Project name	M54 to M6 Link Road
File reference	
Status	Final
Author	The Planning Inspectorate
Date	13 November 2019
Meeting with	Highways England
Venue	Temple Quay House
Meeting objectives	Draft Documents and submission
Circulation	All attendees

M54 to M6 Link Road

Section 51 Advice –draft Application Document by Highways England for PINS review

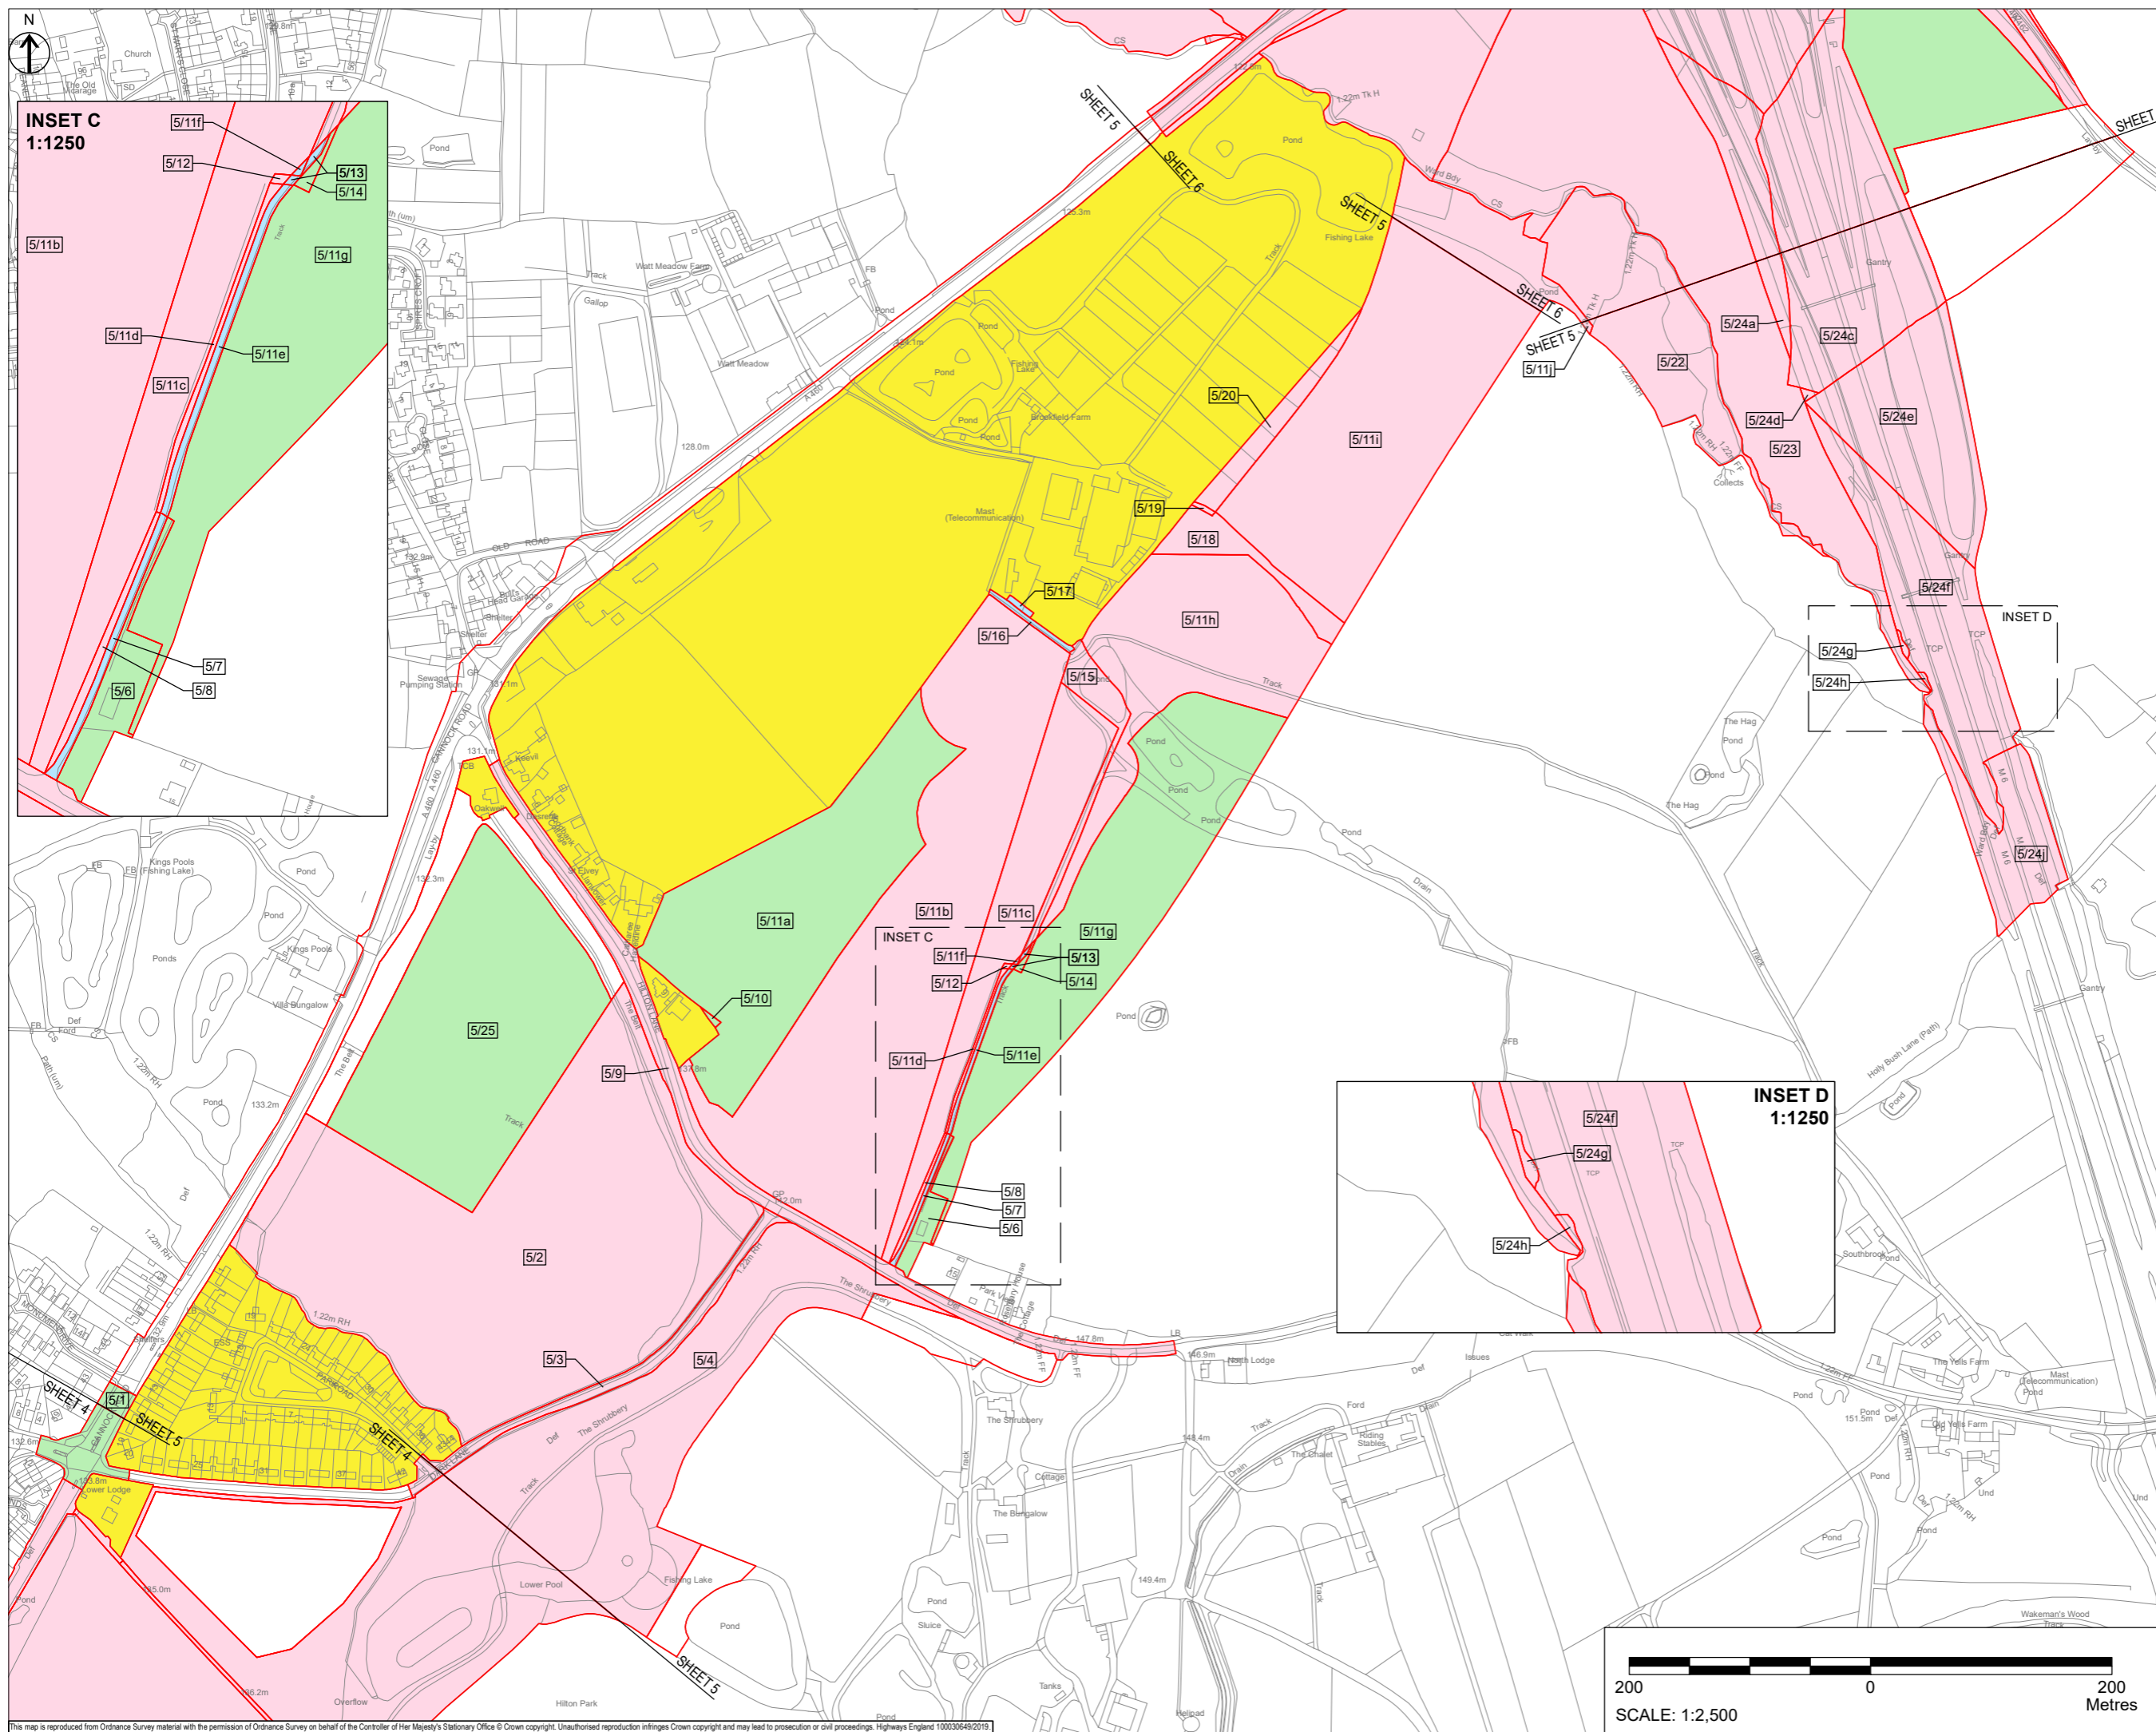
2.	General		Please ensure plans and all references to plans are consistent throughout the suite of application documents upon submission.
3.	General		<p>A number of plots lie between red boundary lines and are not visible on the draft Land Plan, for example; 5/1c & 5/10.</p> <p>The Applicant is advised to note that, as per the DCLG guidance related to procedures for the compulsory acquisition of land, Annex C;</p> <p><i>'Where the order involves the acquisition of a considerable number of small plots, the use of insets on a larger scale is often helpful'.</i></p>

5.		<i>LAND PLANS REGULATION 5(2)(i) SHEET 5 OF 8</i>	One draft Land Plan submitted, as titled 'Land plans regulation 5(2)(i) sheet 5 of 8. The Applicant is advised to ensure that the outstanding seven maps are robust before submitting as part of the Application.

6.	5/3c		<p>Plot reference does not appear on the map.</p> <p>Listed in the BoR as;</p>

- **Q No. 4 – Draft Land Plans.**
The Applicant expressed its' intention to align the Land Plans with the Work plans upon completion of the documents.

Drawing Title  
**WORK PLANS  
REGULATION 5(2)(J)  
SHEET 6 OF 10**

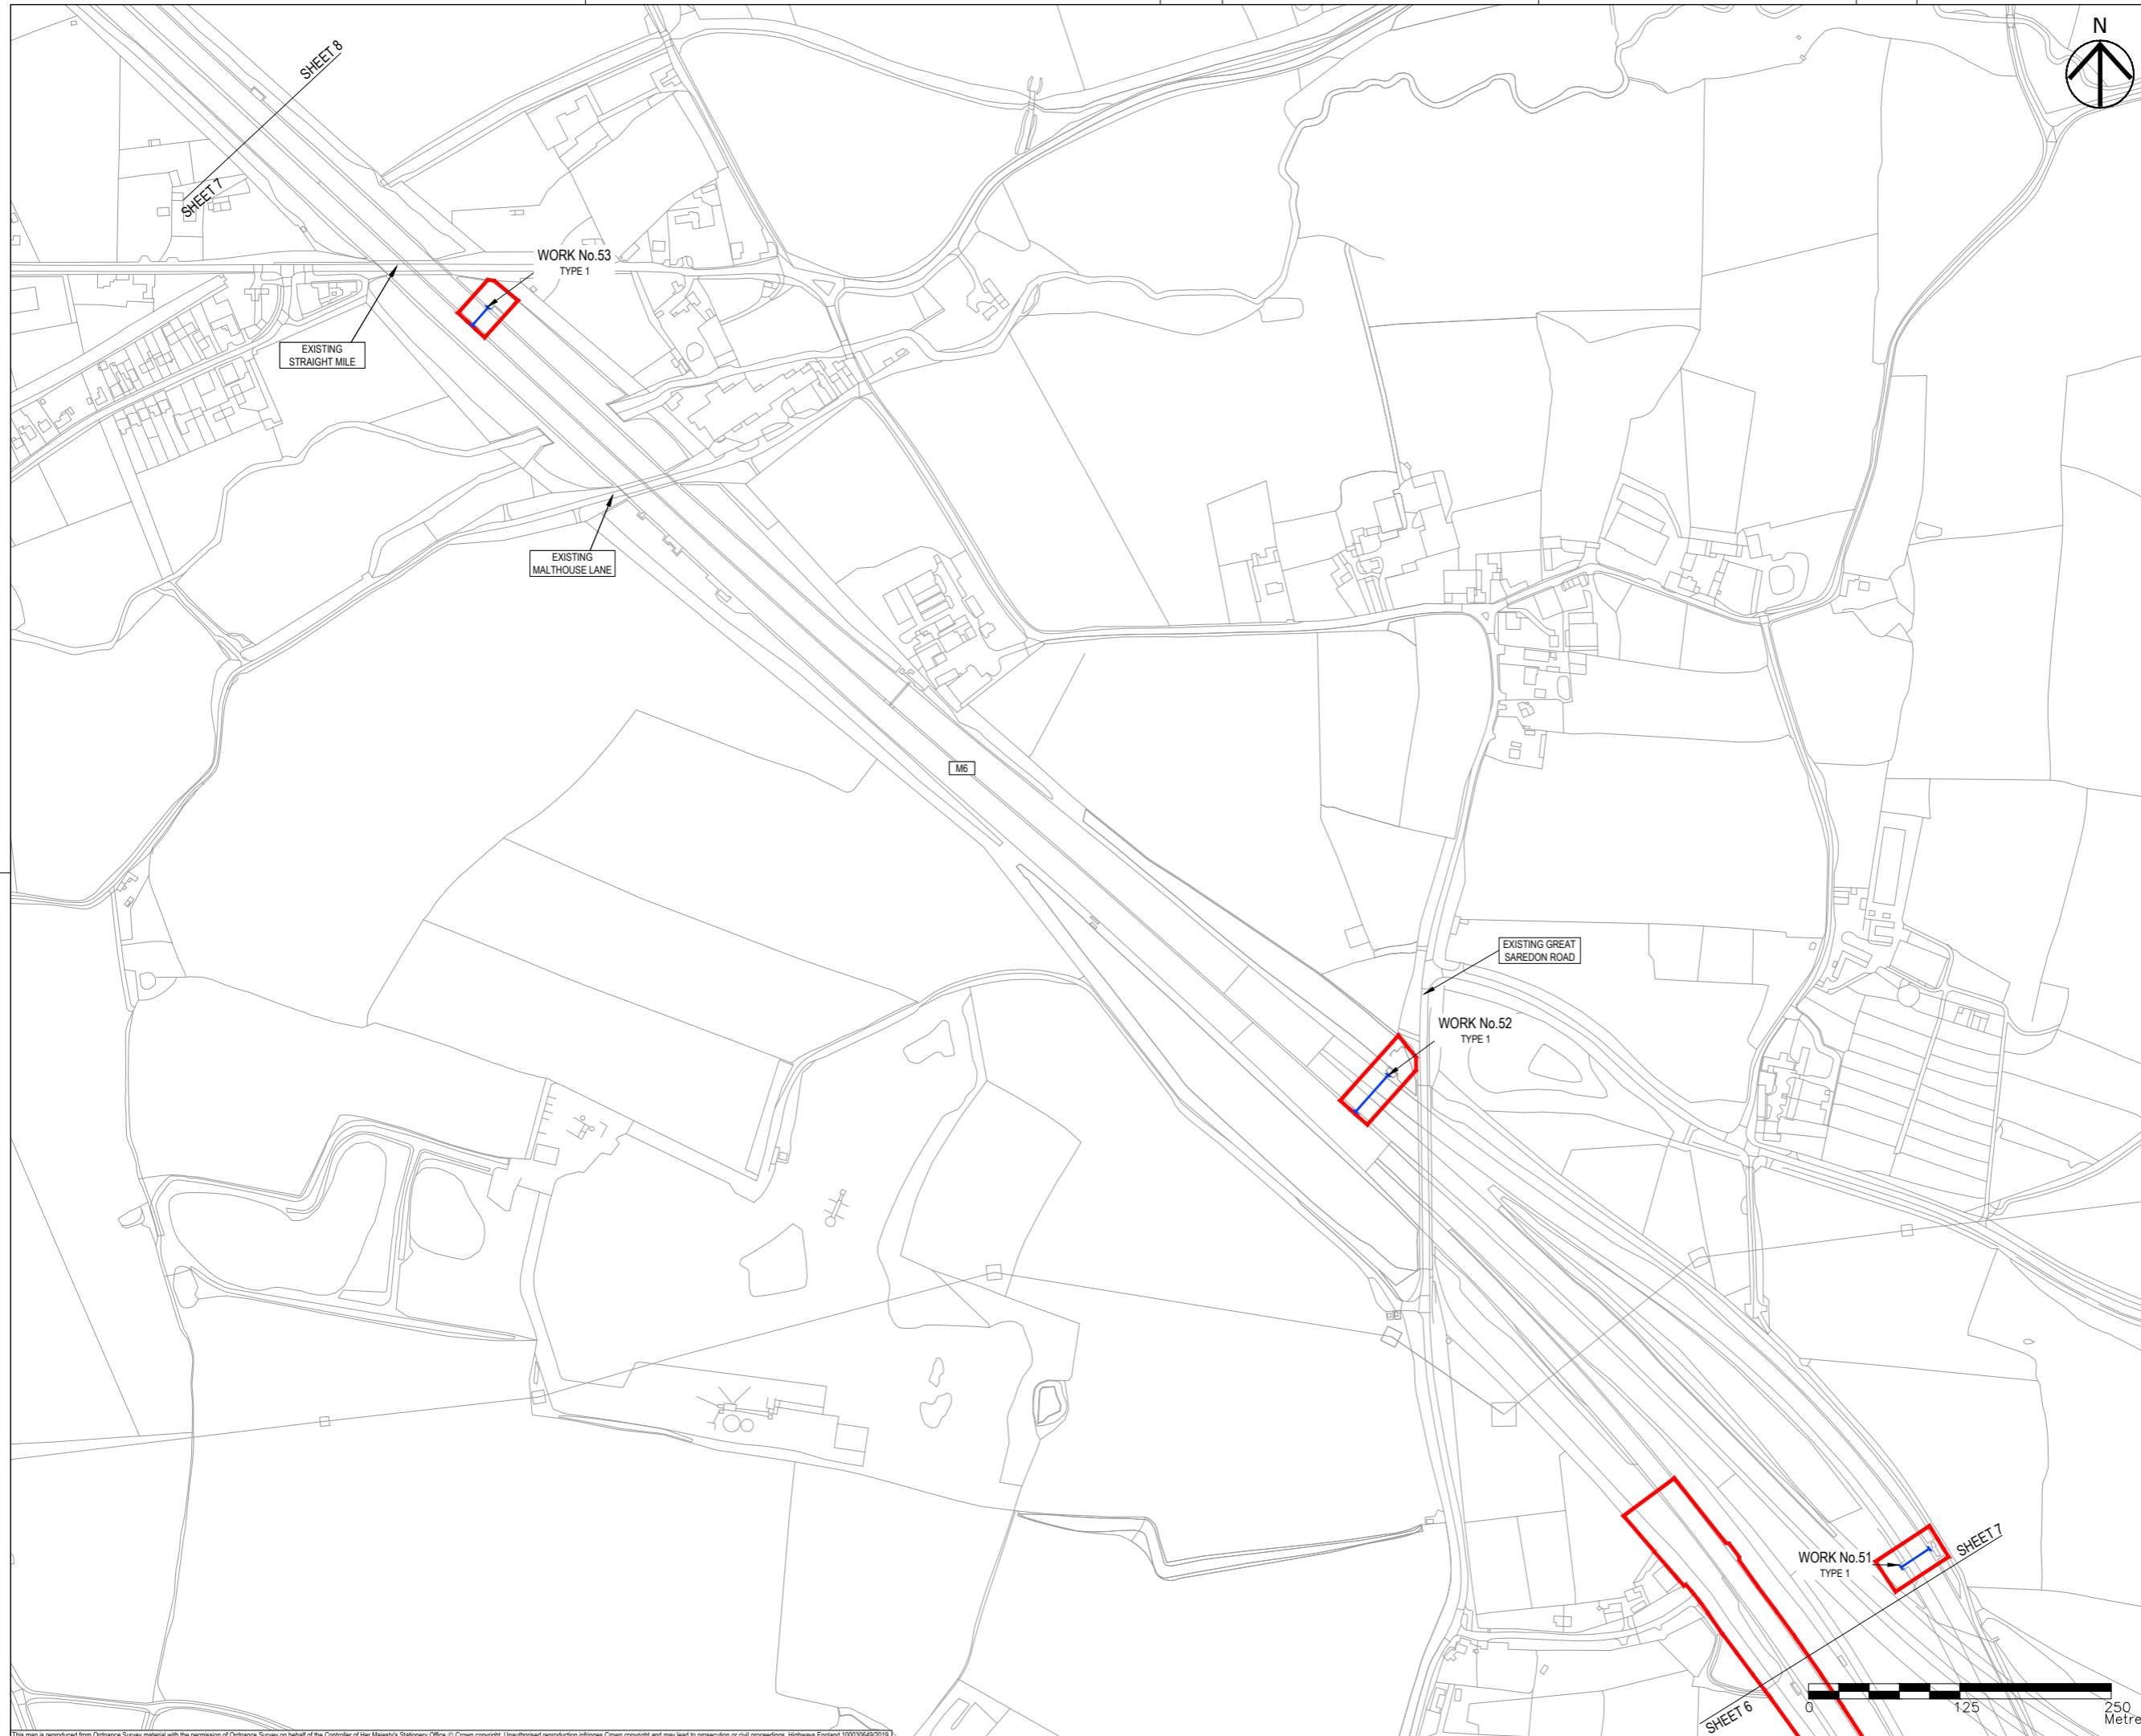
2.		<i>WORK PLAN REGULATION 5(2)(J) SHEET 6 OF 10</i>	One draft work plan submitted as titled 'Work plan regulation 5(2)(J) sheet 6 of 10. The Applicant is advised to ensure that the outstanding nine maps are robust before submitting as part of the Application.

3.	Work No.60		Listed in dDCO Schedule 1 as; <i>'the installation of drainage attenuation and treatment systems to the south of M6 Junction 11. Works to include the installation of a balancing pond and swale to provide attenuation and treatment.'</i> This should be clearly defined or identified on the key.
